<b>Project name</b>	Immingham Eastern Ro-Ro Terminal
<b>File reference</b>	TR030007
<b>Status</b>	<b>Final</b>
<b>Author</b>	The Planning Inspectorate
<b>Date</b>	06 February 2023
<b>Meeting with</b>	The Applicant
<b>Venue</b>	Microsoft teams
<b>Meeting objectives</b>	Project Update meeting
<b>Circulation</b>	All attendees

### Application by Associated British Ports for an Order Granting Development Consent for Immingham Eastern Ro-Ro Terminal

### **Application by Associated British Ports for an Order Granting Development Consent for the Immingham Eastern Ro-Ro Terminal**

**IMMINGHAM EASTERN  
RO-RO TERMINAL  
DESIGNATED CONSERVATION SITES**

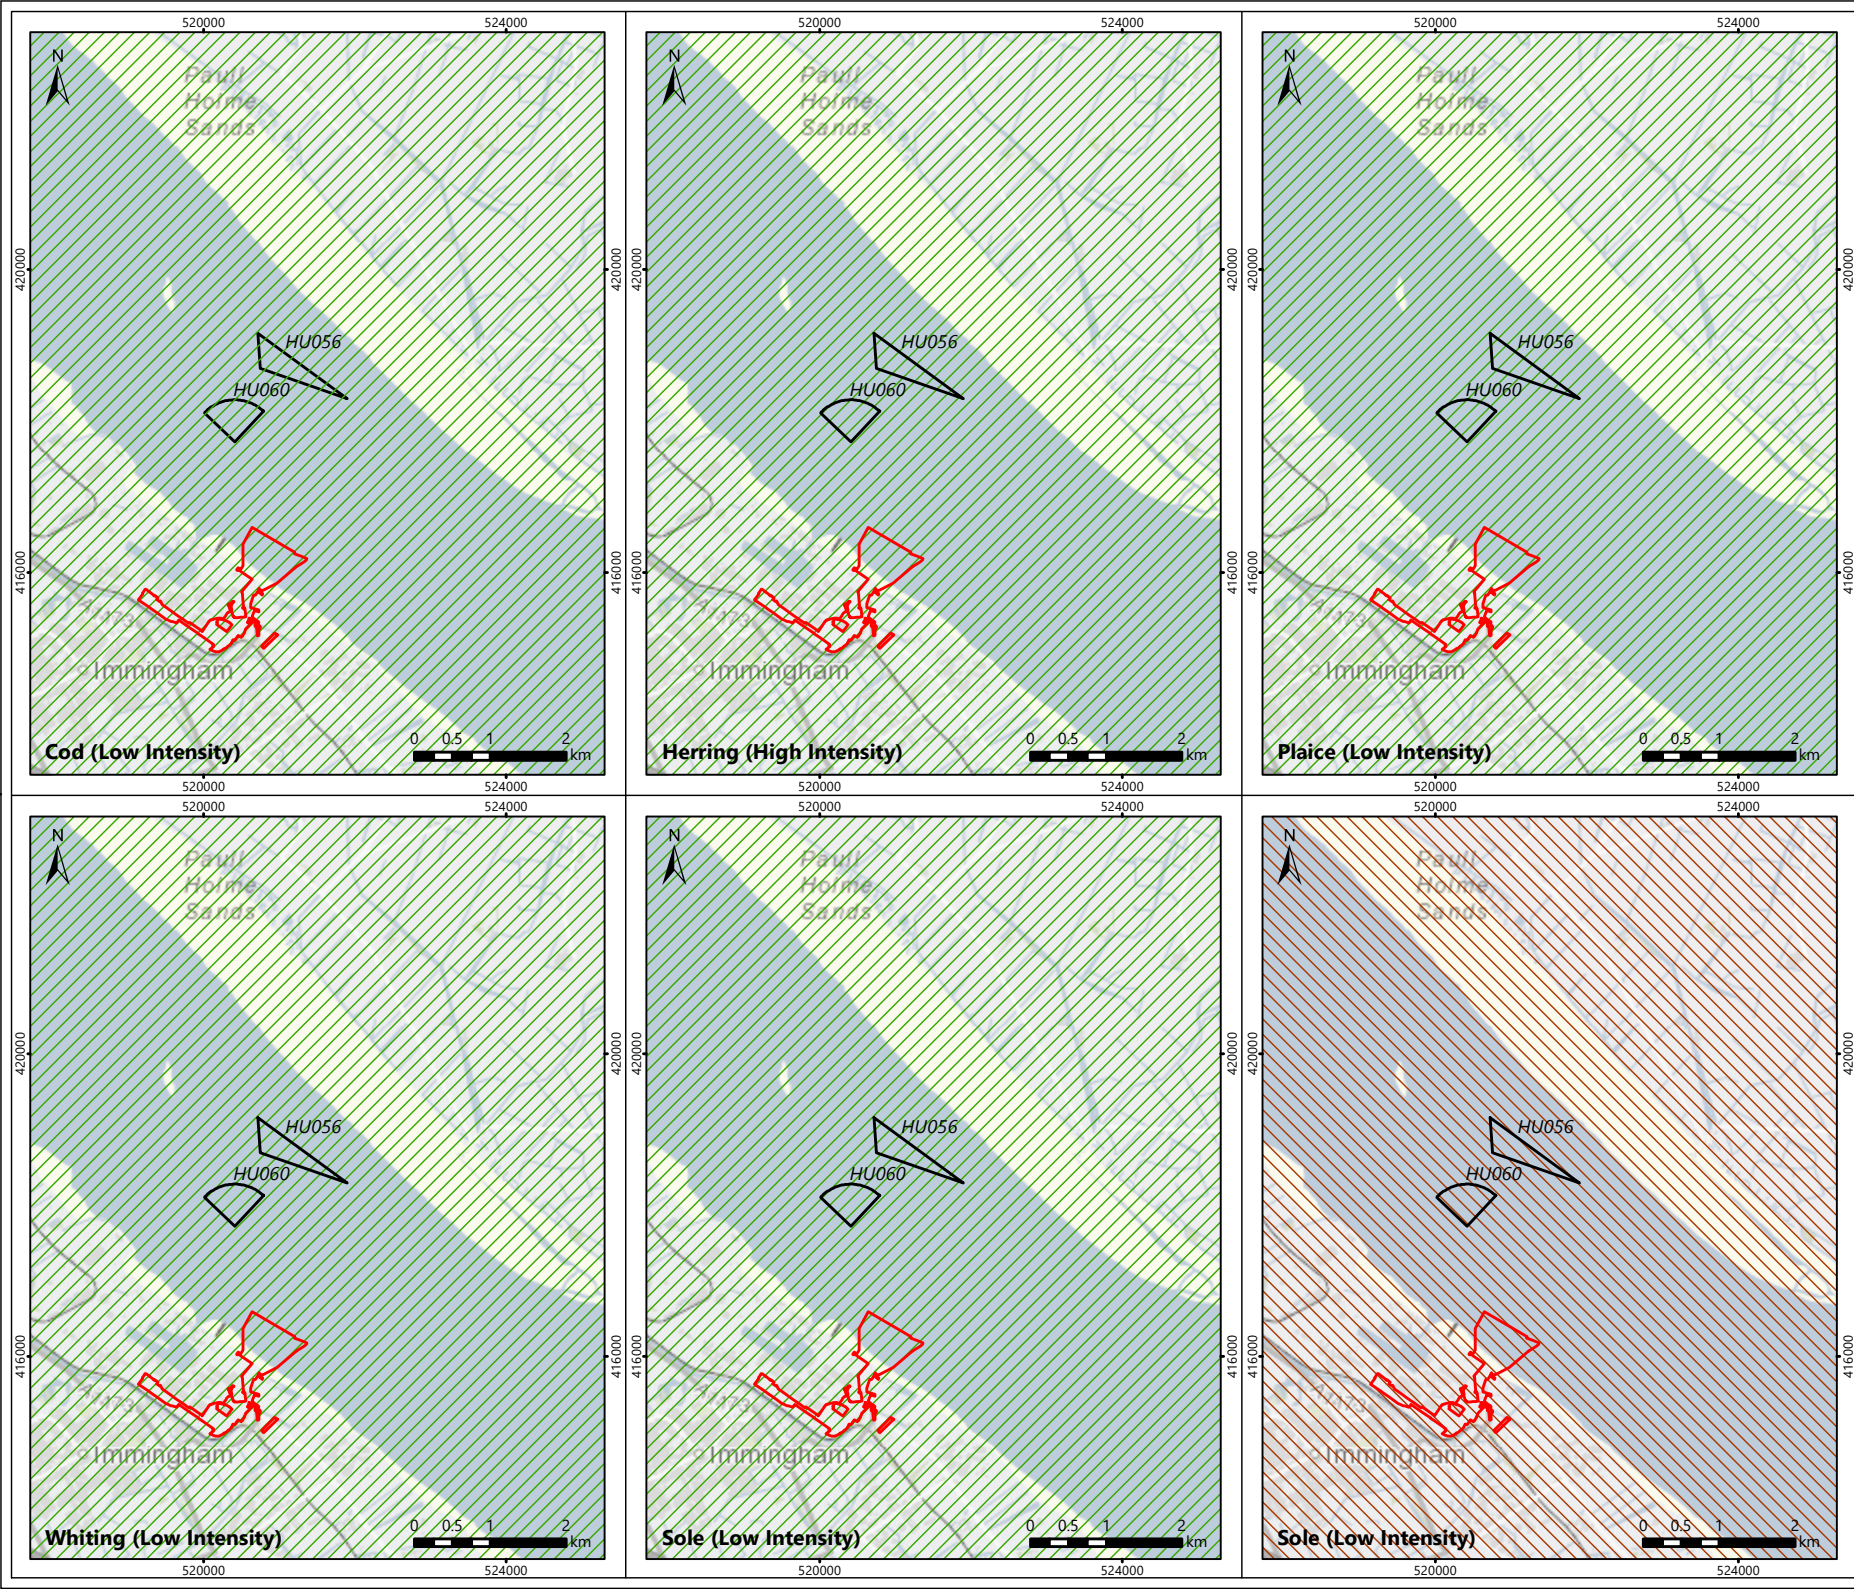
The figures showed the location of the statutorily designated wildlife sites in relation to the Proposed Development but did not show the full extent or boundaries for those sites. Any resubmitted application should be accompanied by plans/maps that show the full extent of the statutorily designated wildlife sites.

Drawing title		Lighting Project: ABP Humber, Project Sugar External Lighting SHEET 1 OF 3	
Drawing status		FOR COMMENT	
Scale	1:2500@A1	Suitability	S3
Jacobs No.	B2429400	Rev	
Client No.			P02
Drawing number		B2429400-JAC-00-ZZ-SK-ZZ-0150

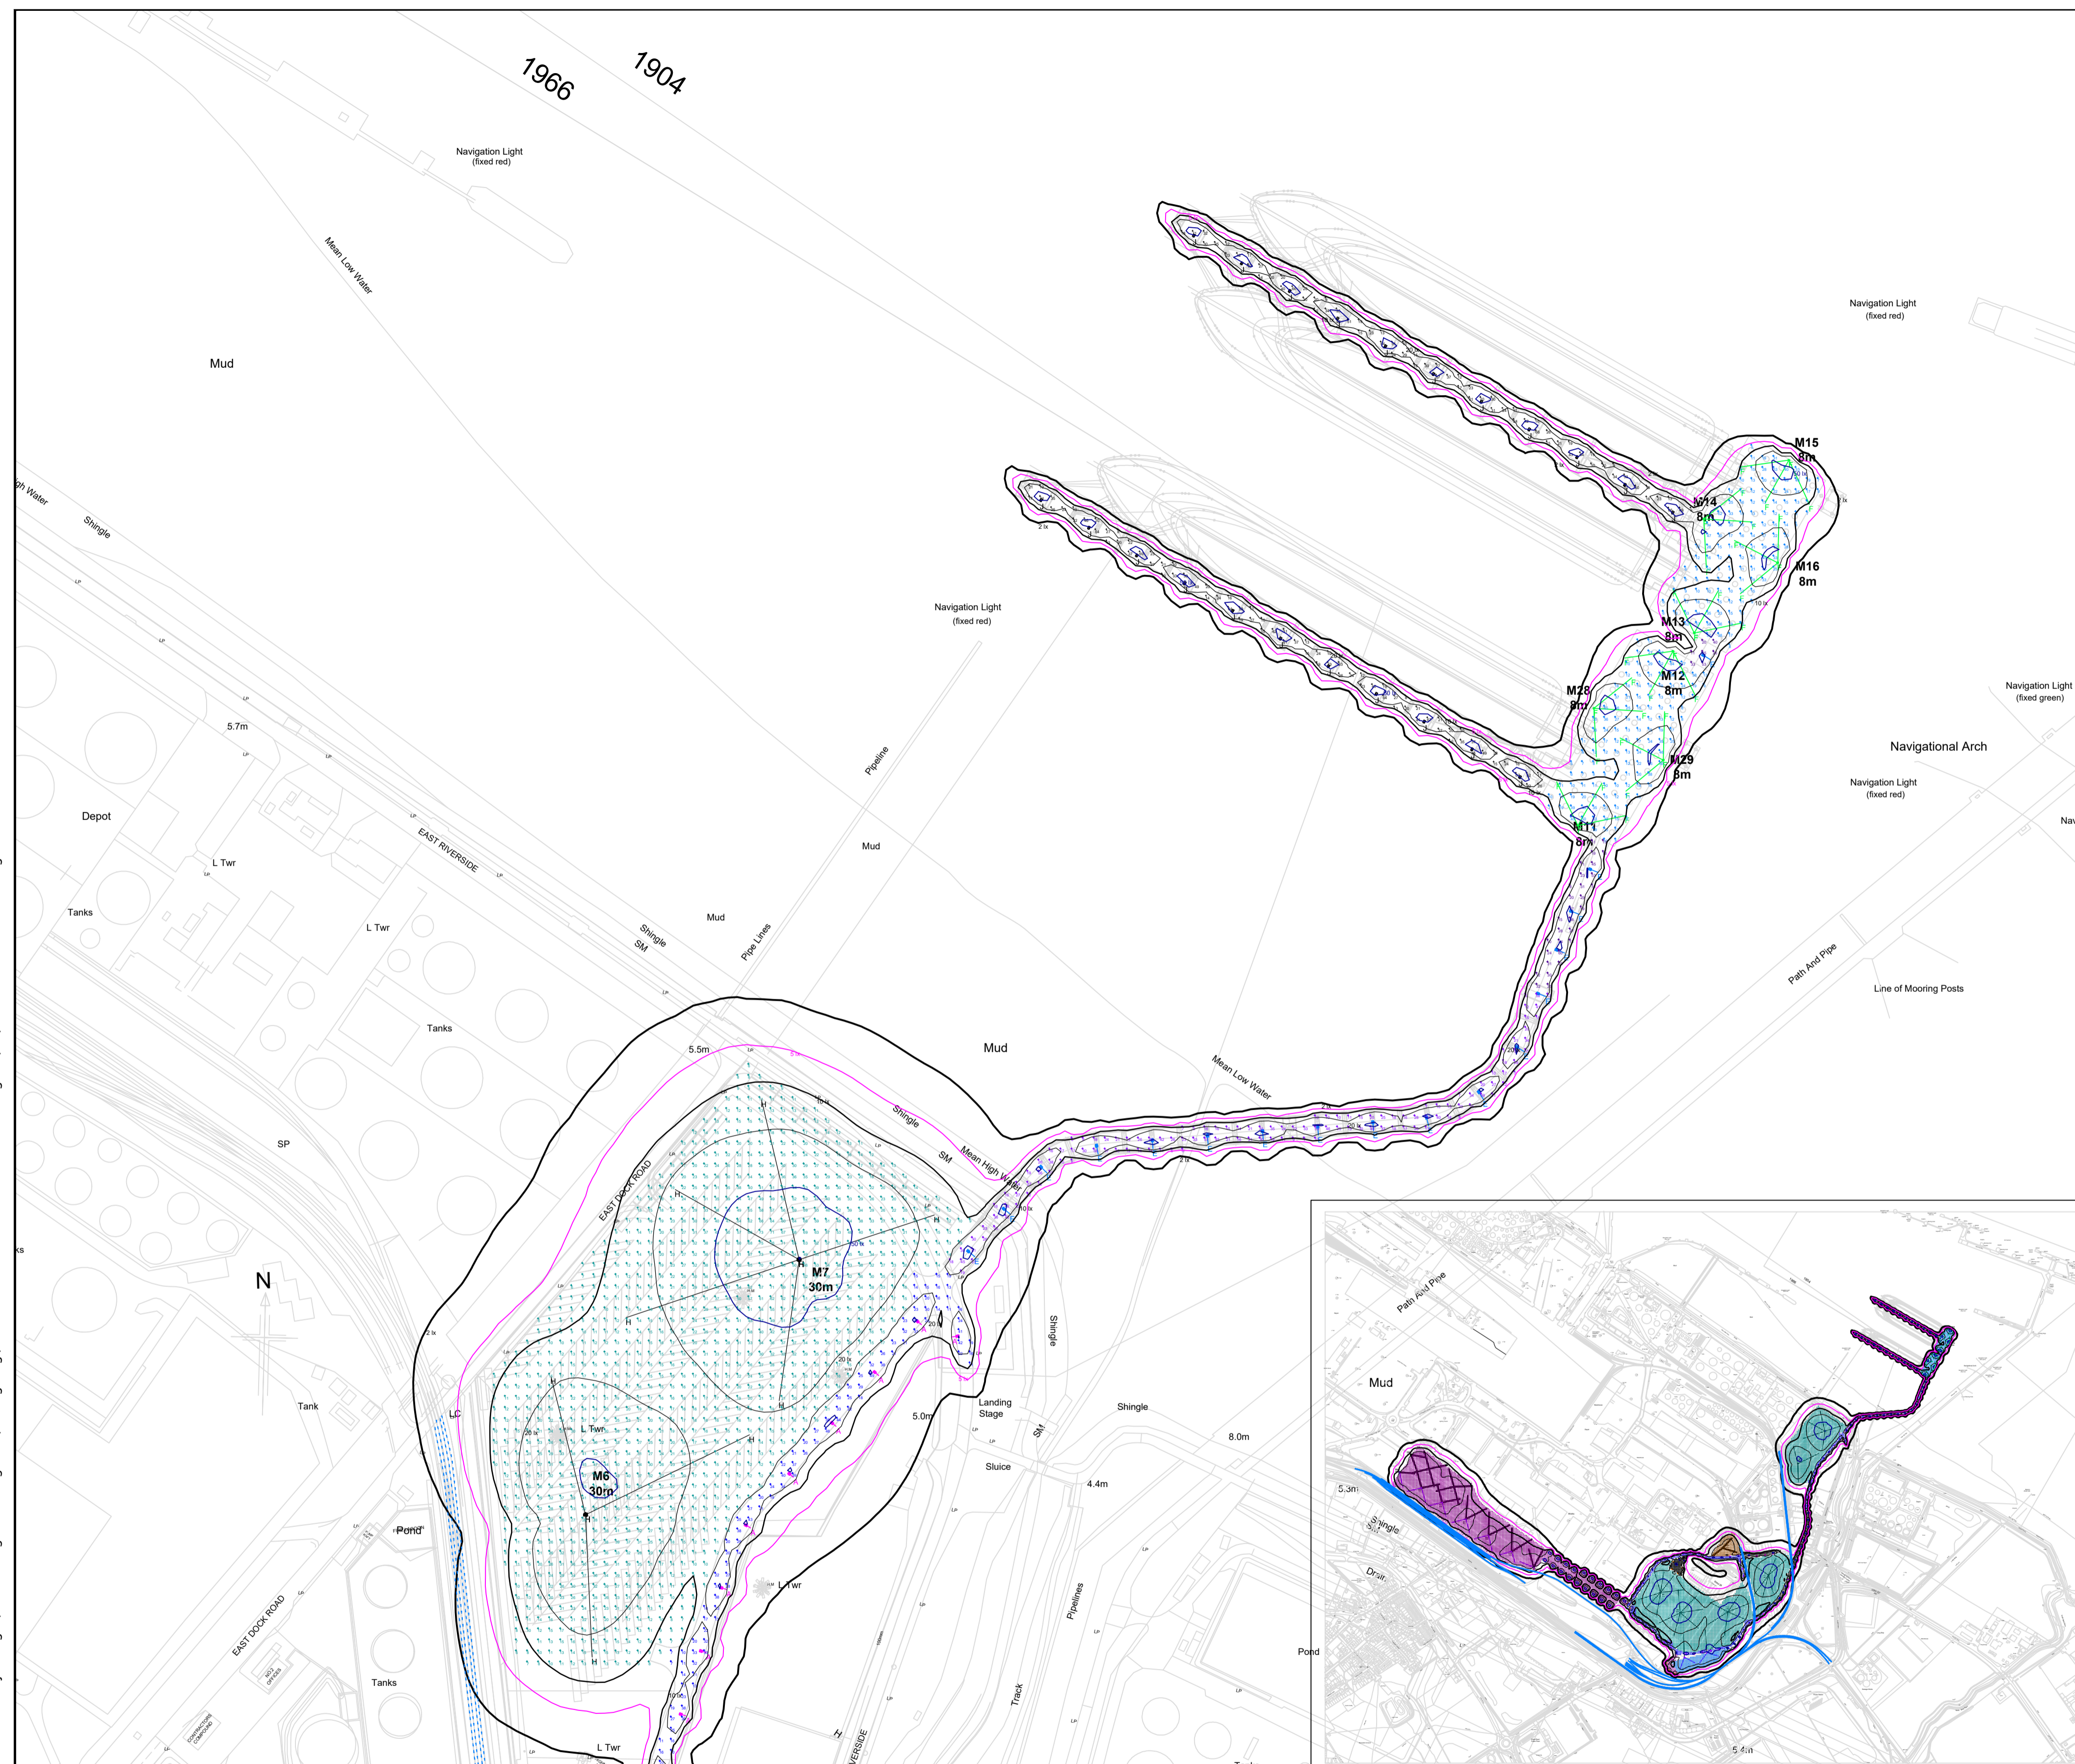
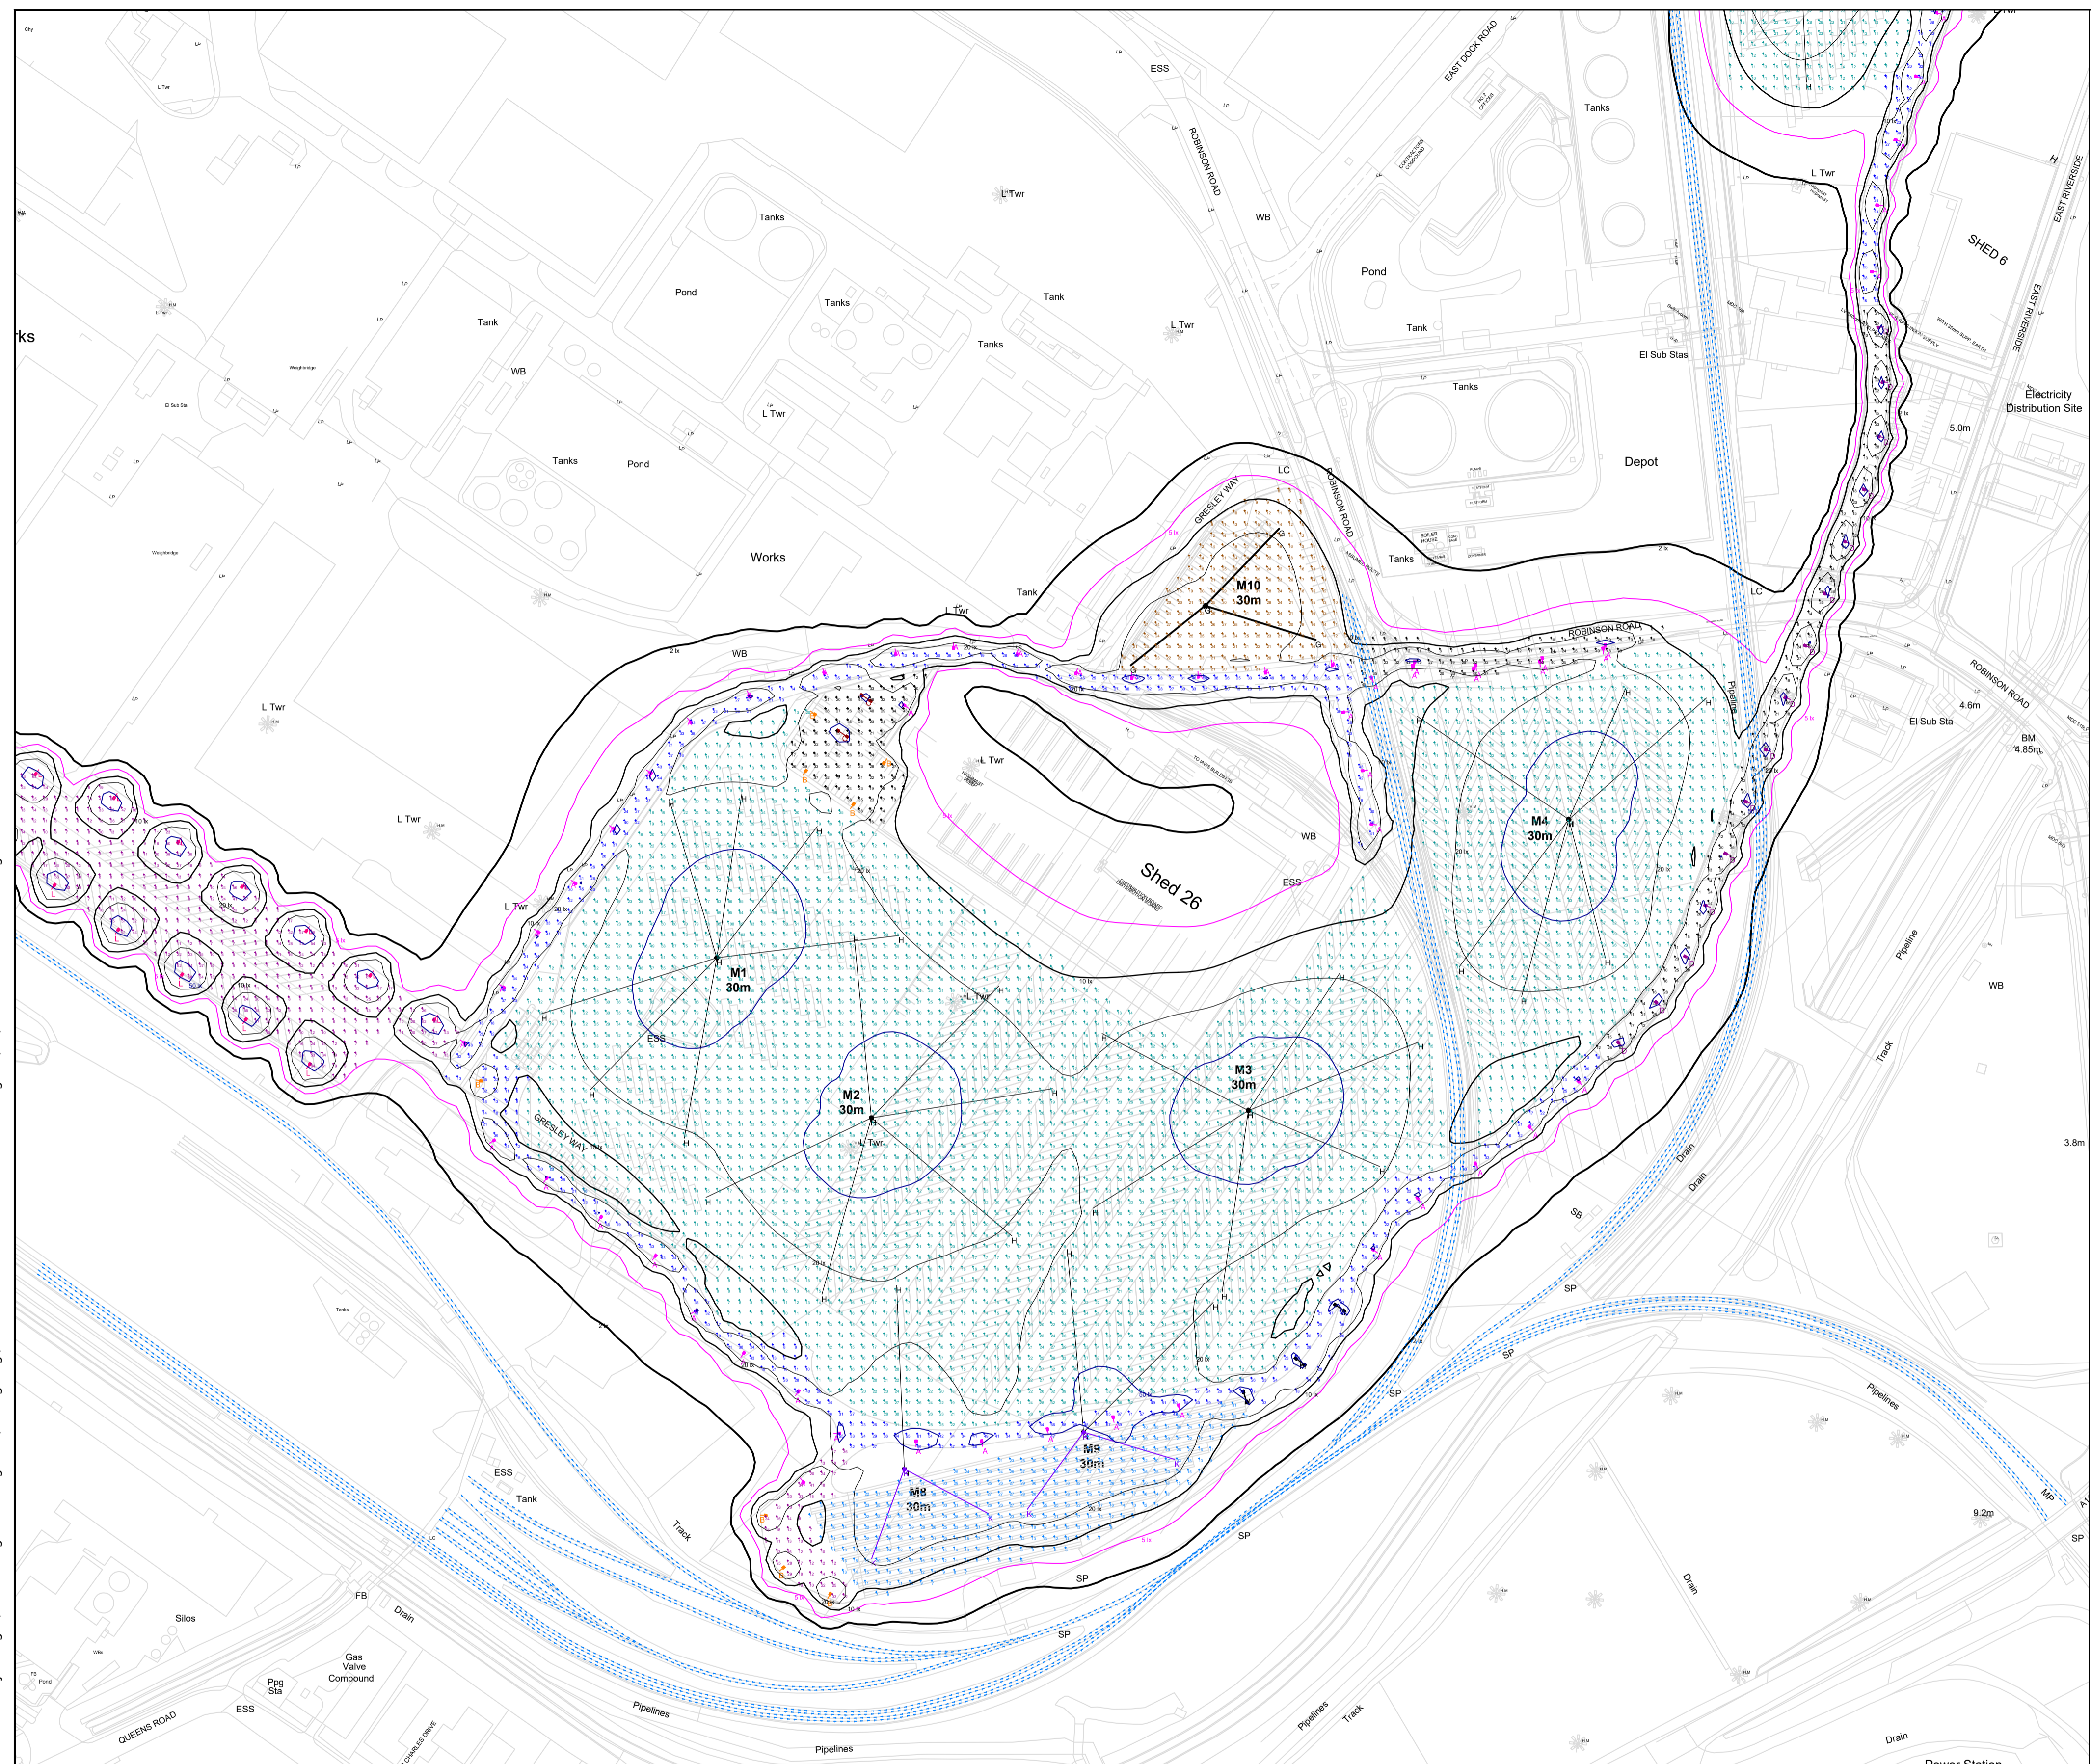
The plan in Appendix A “Concept Lighting Layout” of the lighting plan document did not have a scale bar and has been drawn at a scale of 1:3000 for a paper size of AO.

The applicant is advised that it should reconsider the presentation of the information presented in any resubmitted lighting plan document so that the location of any lighting masts and columns etc can readily be identified on a standalone plan, with information of relating to the predicted lighting intensity being presented on a separate plan. Those plans, and for that matter any other plans that are submitted, should have scale bars shown on them, be drawn at scales using commonly used scales and be capable of being scaled.

The Applicant confirmed it will re-size and adjust the scales accordingly following on from the S51 provided by the Applicant.
